ADDENDUM TO HERITAGE IMPACT STATEMENT: 85 HARRINGTON STREET, THE ROCKS, NOVEMBER 2018

This letter is provided as an addendum to the original Heritage Impact Statement (HIS) prepared by Urbis in January 2016 for the State Significant redevelopment of the above-mentioned site. This letter addressed proposed amendments to the current approved scheme.

This HIS letter responds to the amendments in the plans package prepared by FJMT

- S4.55 (1a) submission package revision A5 dated November 2018
- Landscape architecture design report Rev 6, dated November 2018

title  
**Plans**  
**Roof Plan**

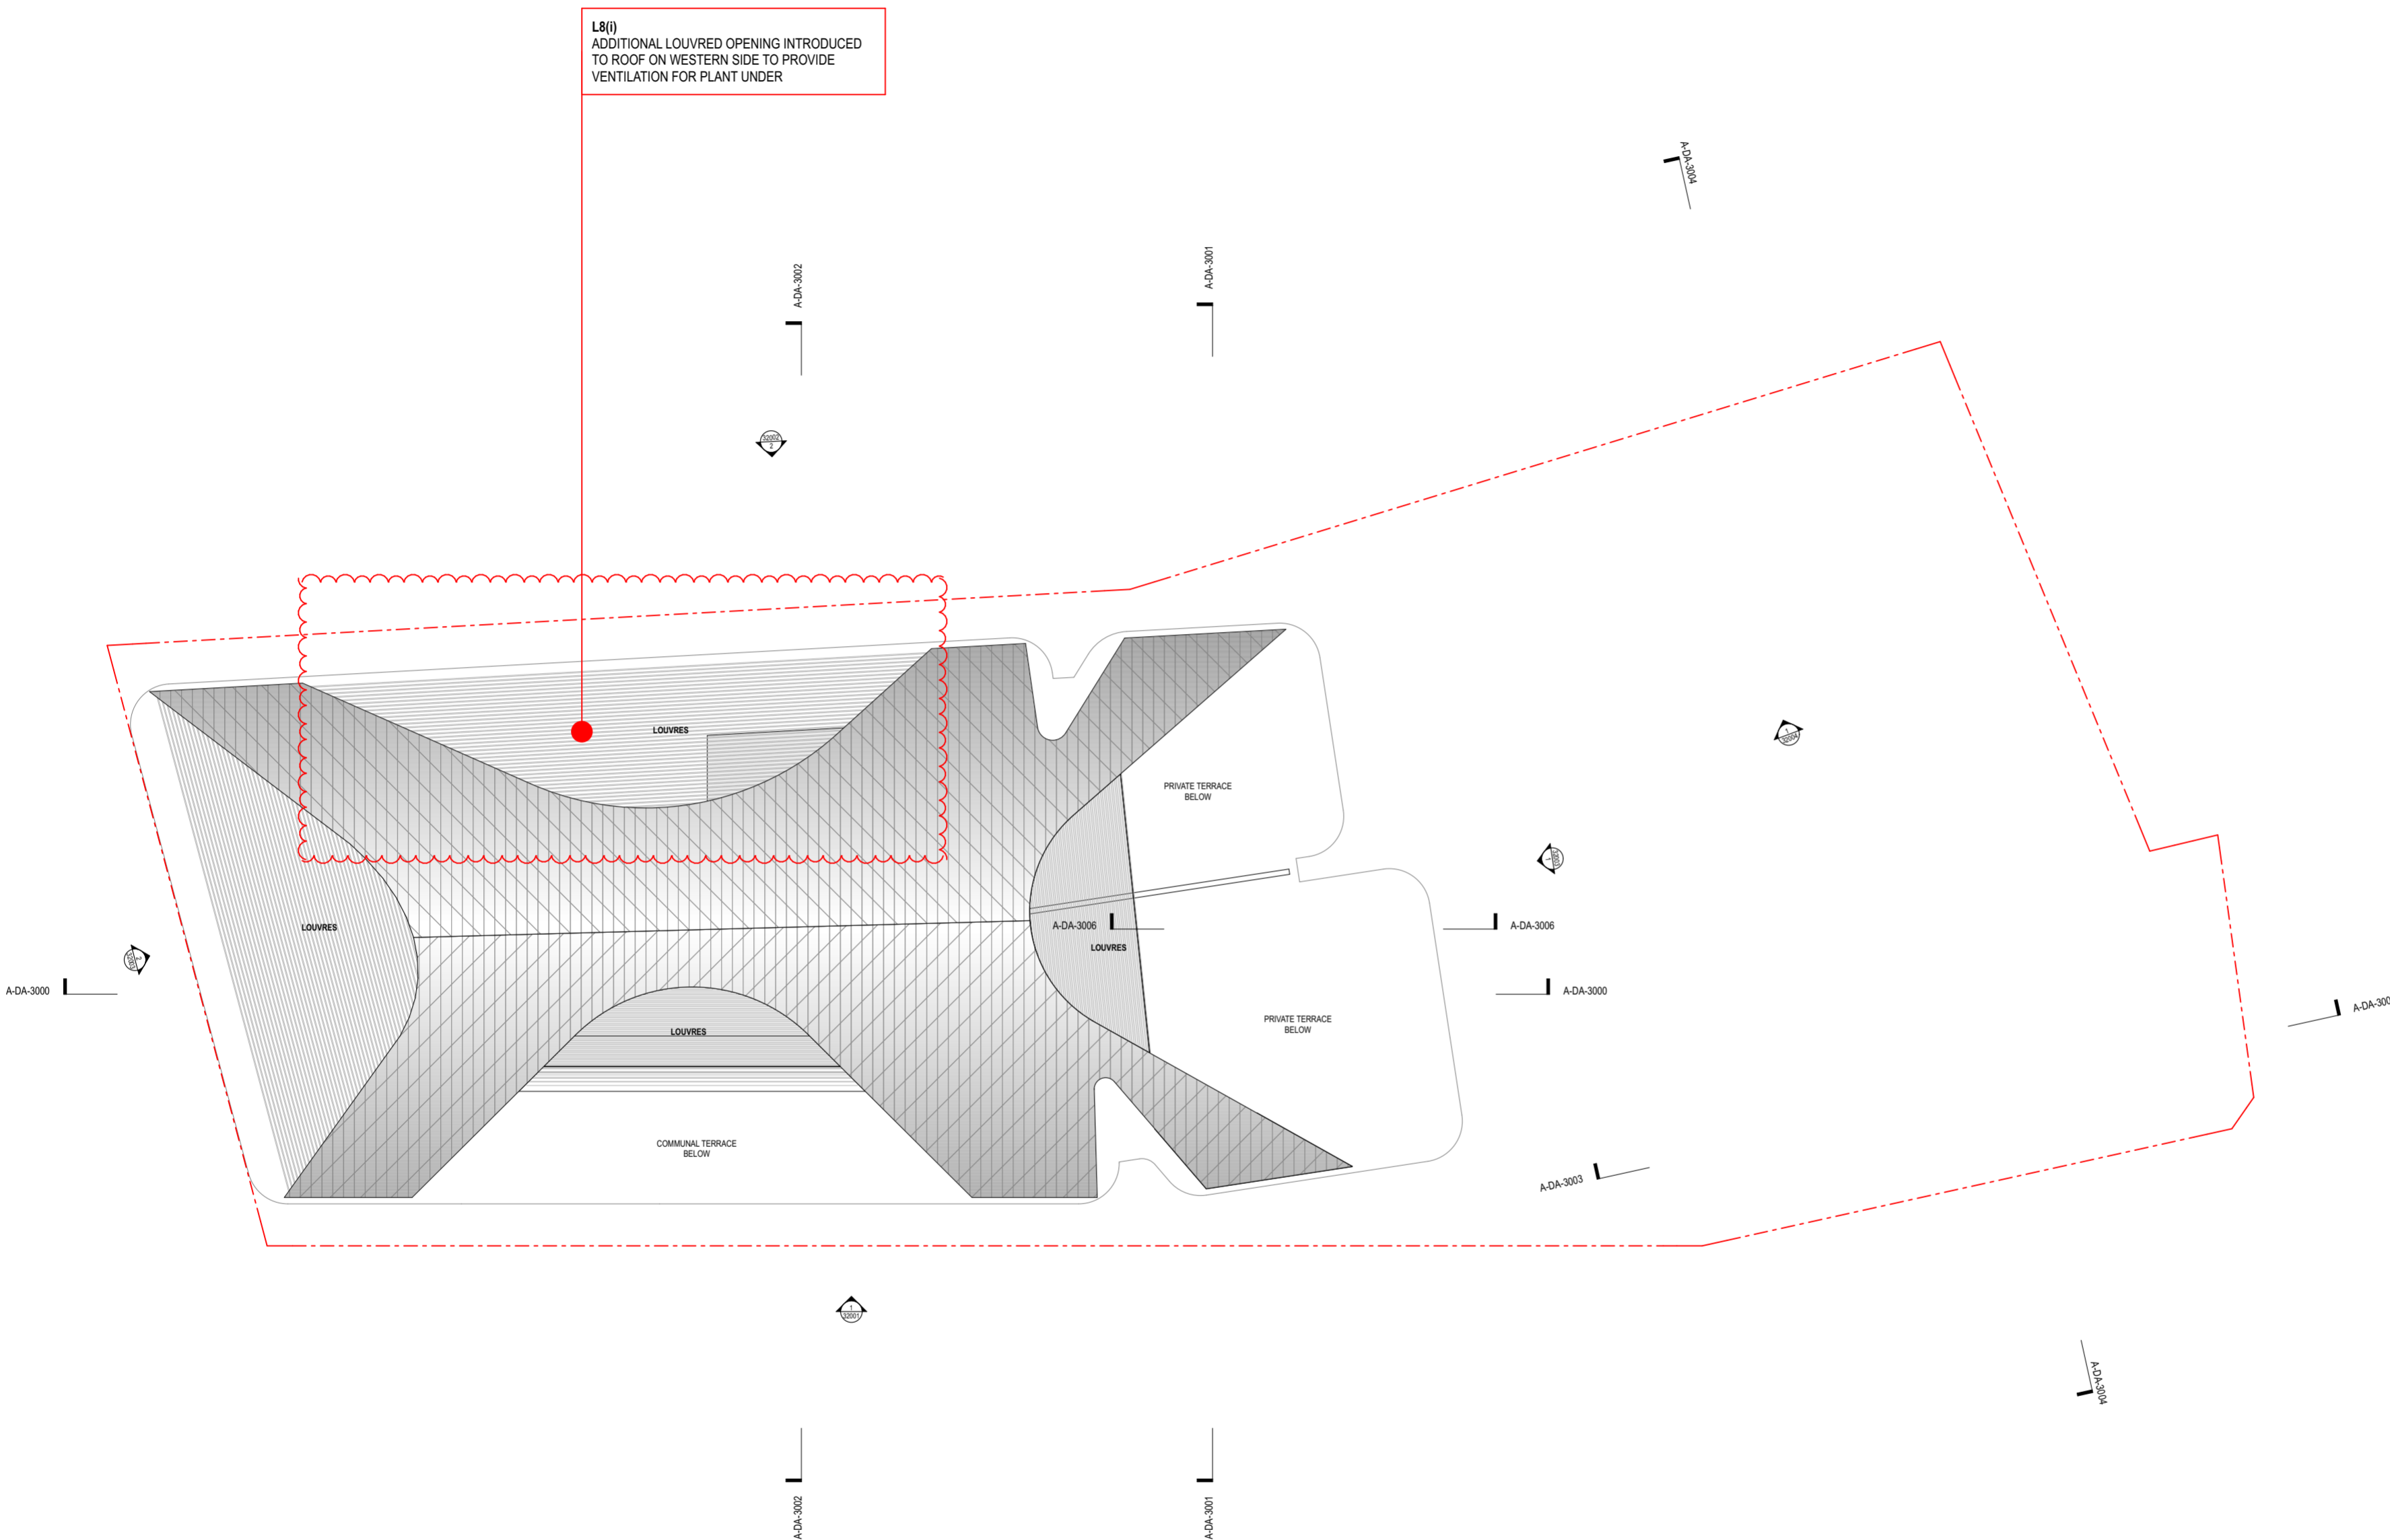
8.0 Additional louvred opening to roof on western side to provide ventilation for plant

The proposed changes to the roof do not alter the overall form, scale or presentation of a solid roof form and therefore have no change to the impact assessment on heritage grounds.

title  
**Elevations**  
**Outer East Elevation (Harrington Street)**

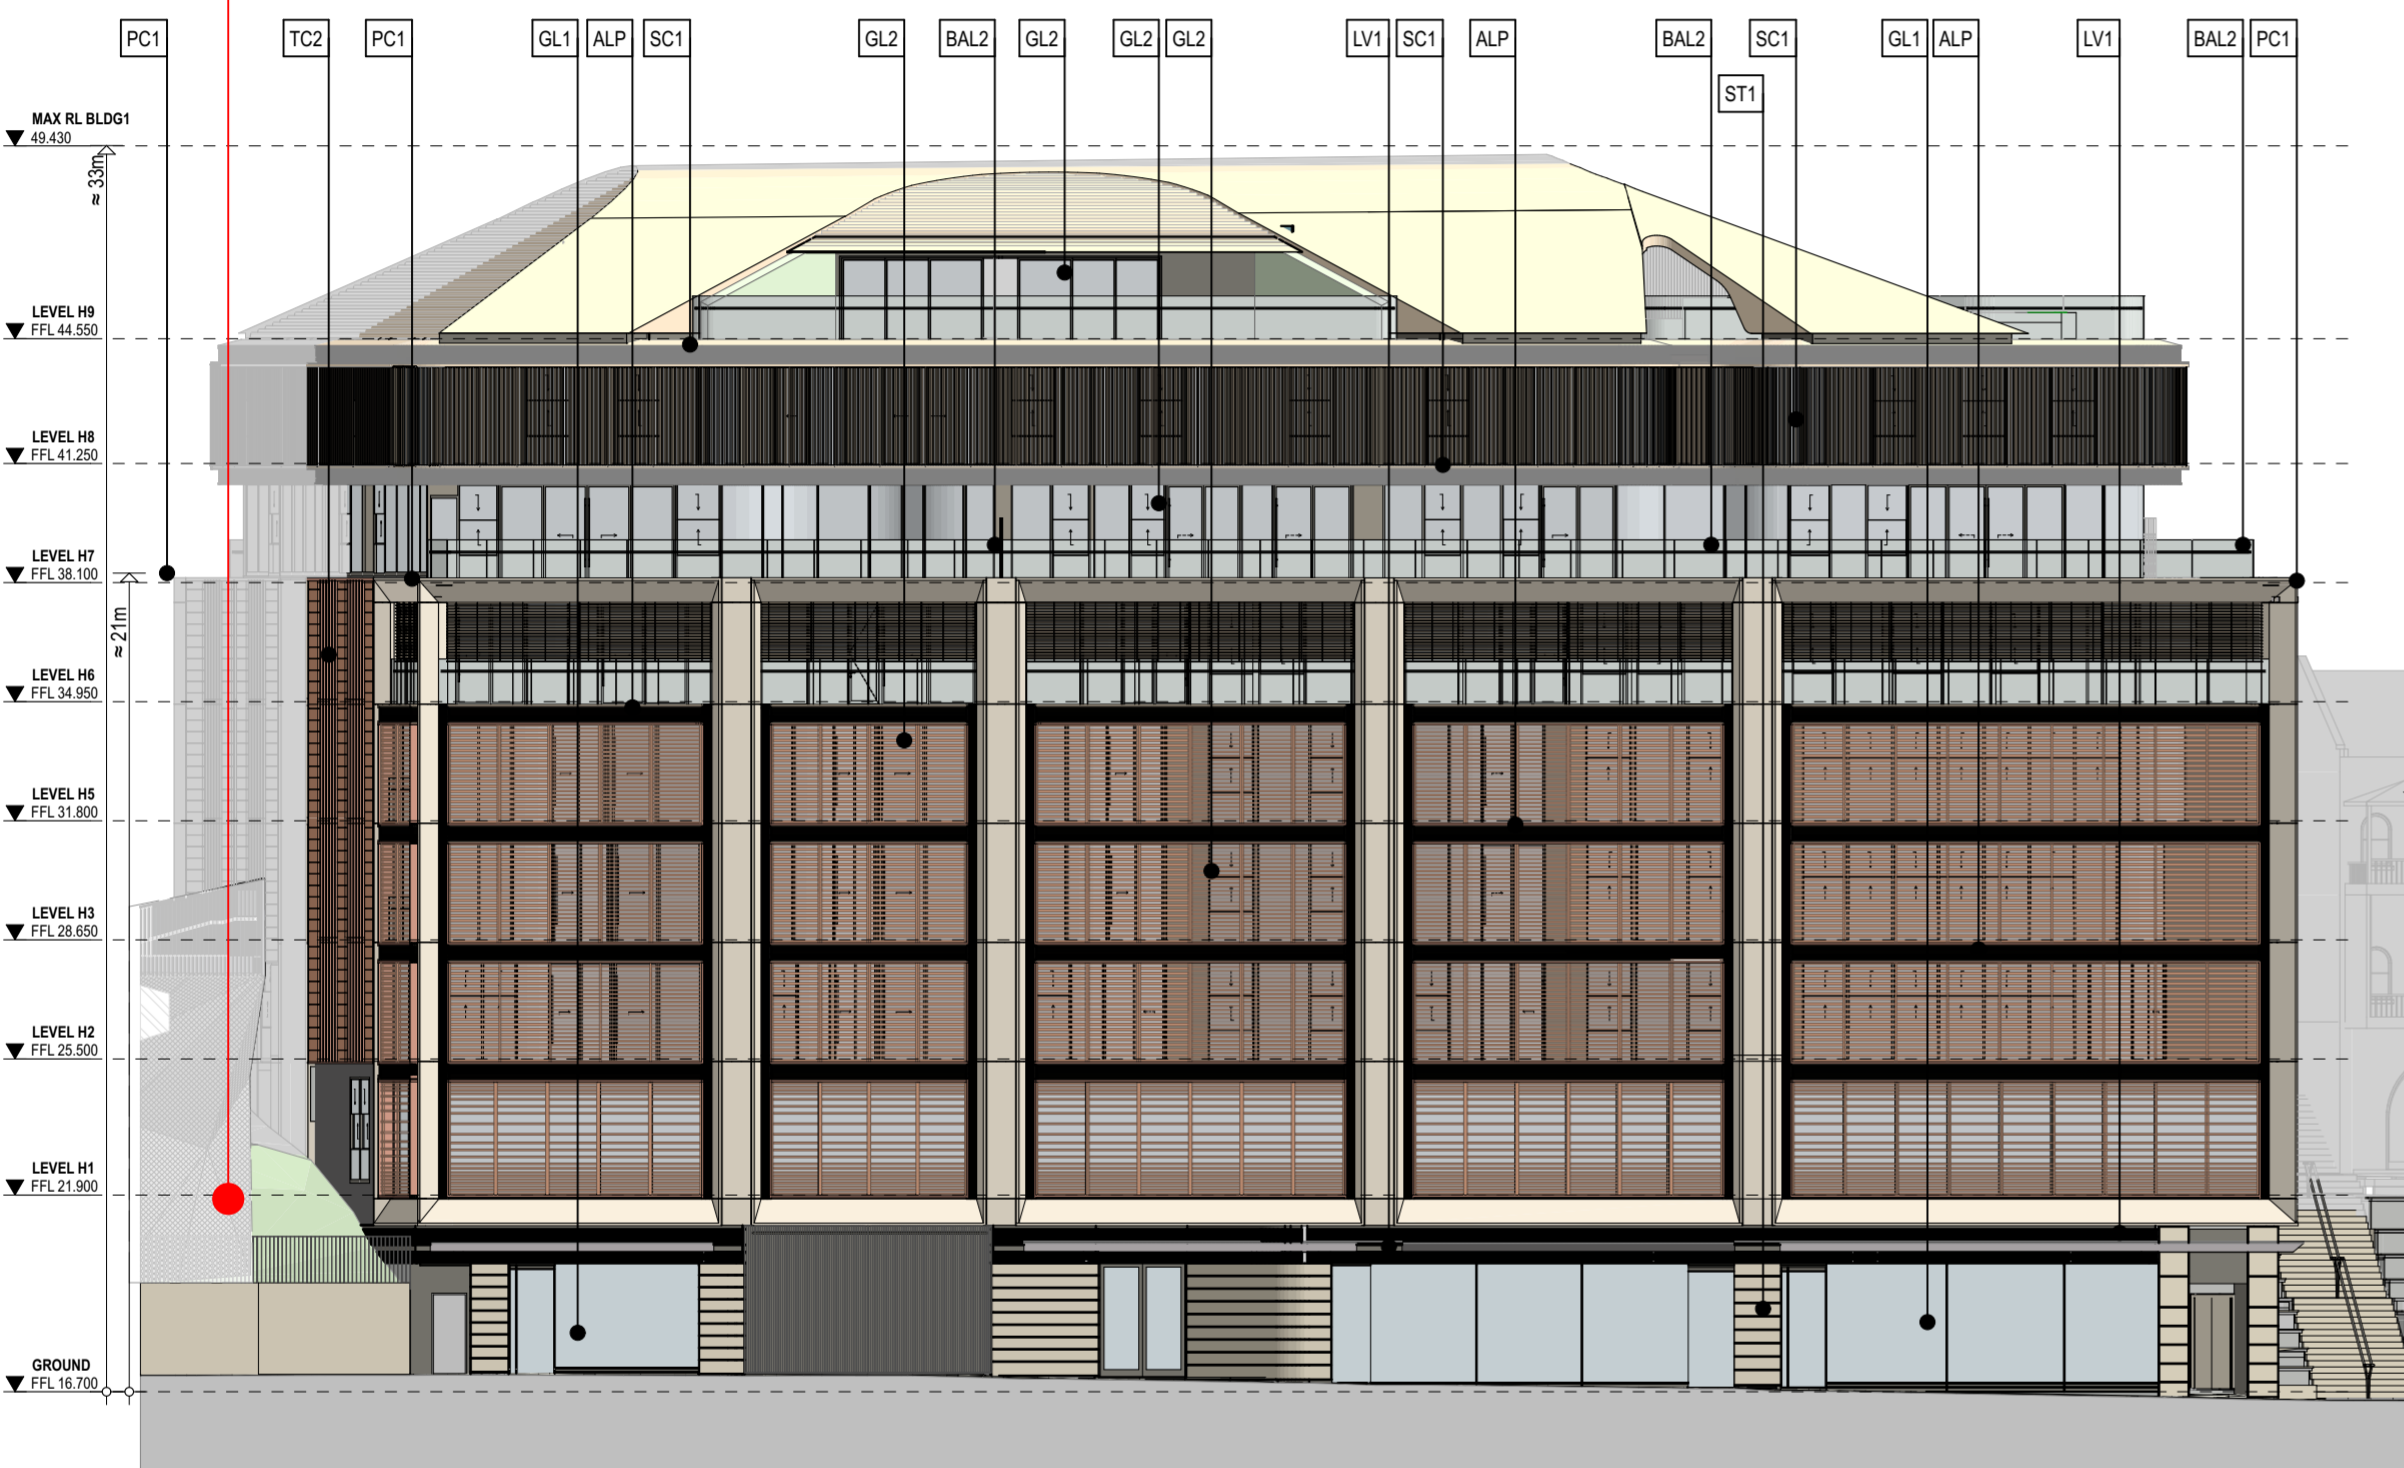
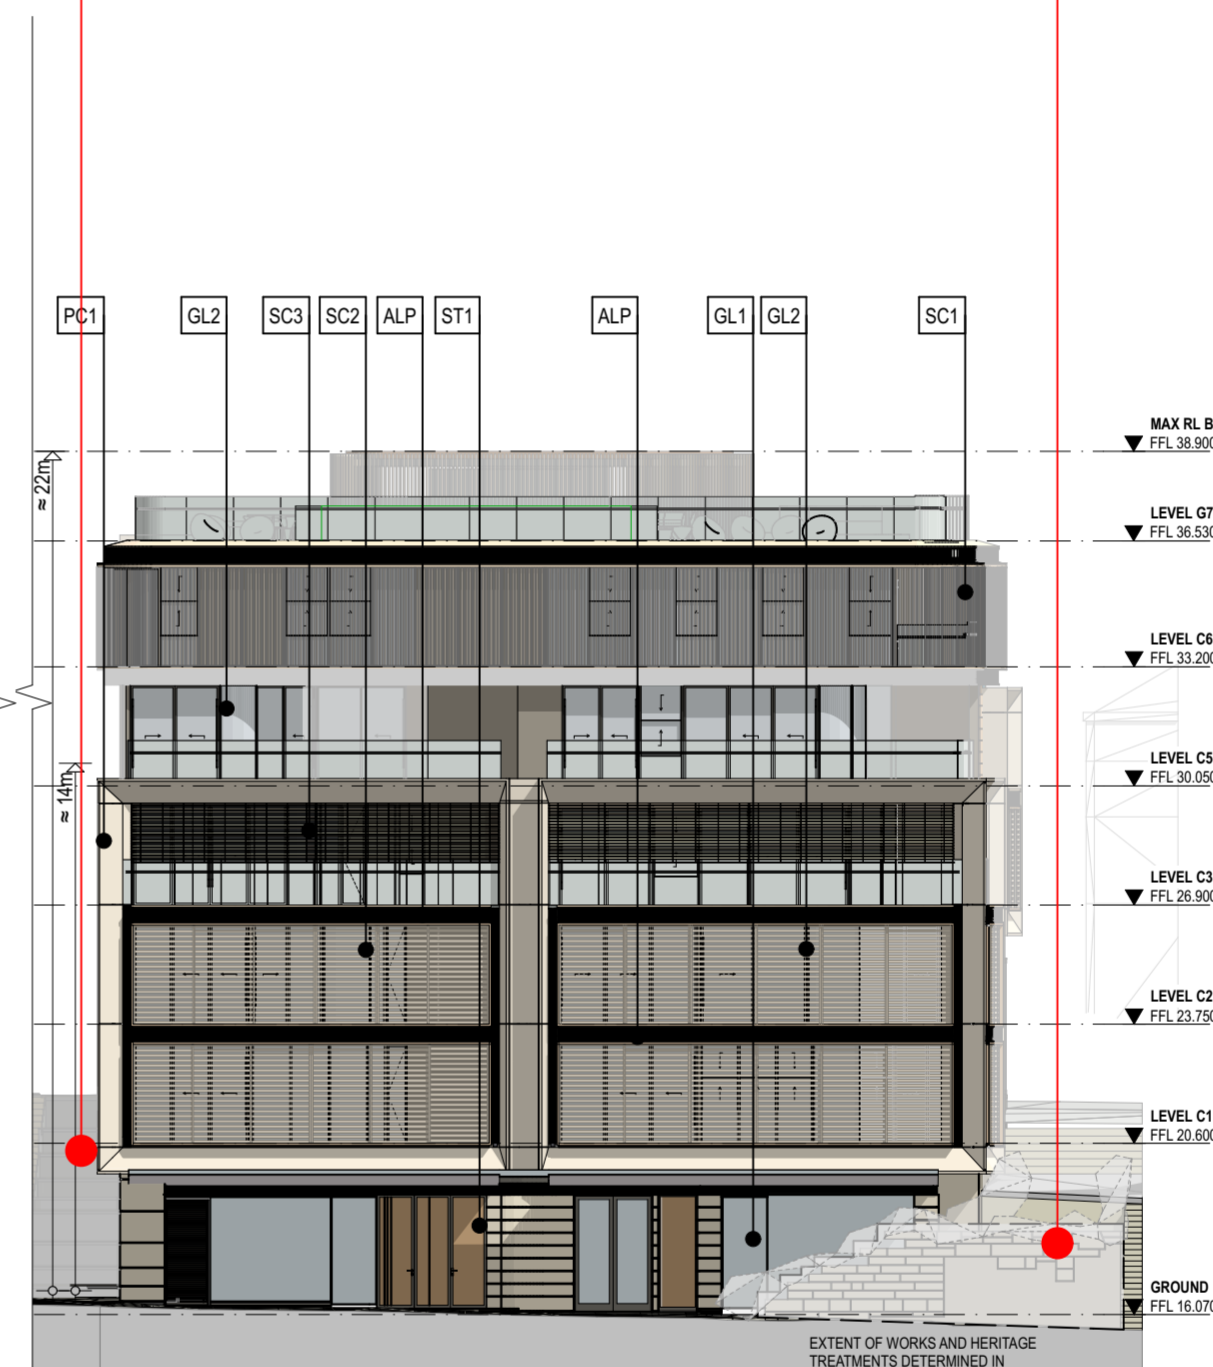
10.0 Minor alterations Harrington Street facades, and outer north

The changes are minor and related to internal planning and facade detail design layouts. They do not alter the design intent or architectural language response to the heritage context.

We also note the sandstone blockwork and bedrock to the northern corner at the stair junction is being retained in situ, the contemporary building wraps in behind.

In addition to the above, we also advise for reference that the current drawing set has been updated to correct a previous minor error in the original submission. The basement doors to Bakers Terraces that front Cumberland Place are to be retained as the existing opening. The previous drawing set showed this opening incorrectly. This detail is located on drawing DA-3004, detail 1 East Elevation Outer.
